**KITTITAS COUNTY**  
**DEPARTMENT OF PUBLIC WORKS**

**MEMORANDUM**

TO: Mackenzie Moynihan, Community Development Services  
FROM: Christina Wollman, Planner II *cw*  
DATE: July 16, 2007  
SUBJECT: Weber Short Plat SP-07-86

SP-07-

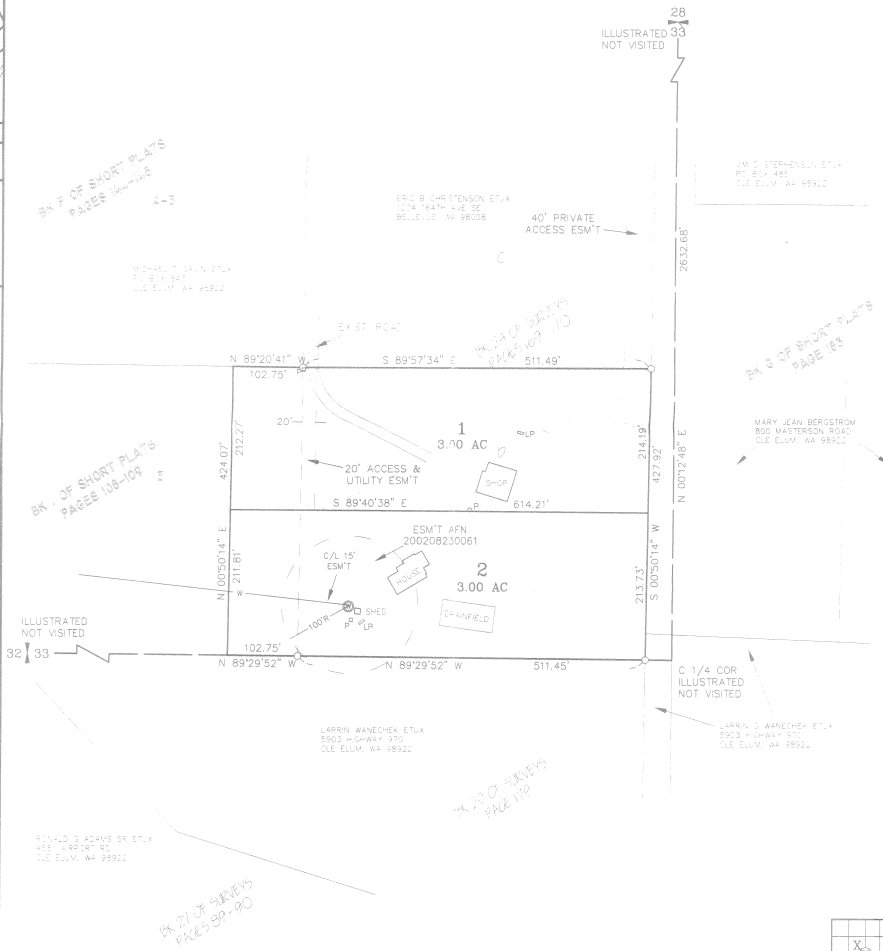
2. Private Road Improvements: Access from Masterson Road to Lot 1 shall be constructed to meet or exceed the requirements of a High-Density Private Road and serve no more than 14 tax parcels. A cul-de-sac shall be constructed at the end of the private road. See current Kittitas County Road Standards, 9/6/05 edition.

- a. Access easements shall be a minimum of 40' wide. The roadway shall have a minimum width of 20', with 1' shoulders, for a total width of 22'.
  - b. Minimum centerline radius shall be 60'.

- c. Surface requirement BST/ACP.
  - d. Maximum grade is 12%.

3. Cul-de-Sac: A cul-de-sac turnaround shall be constructed at the end of the private road. The turnaround shall have an outside right-of-way easement diameter of at least 110' (55' radius) at the closed end. See Kittitas County Road Standards, 9/6/05 edition.

Thank you for the opportunity to comment on the above referenced project. Water availability is needed and the soil logs need to be done.
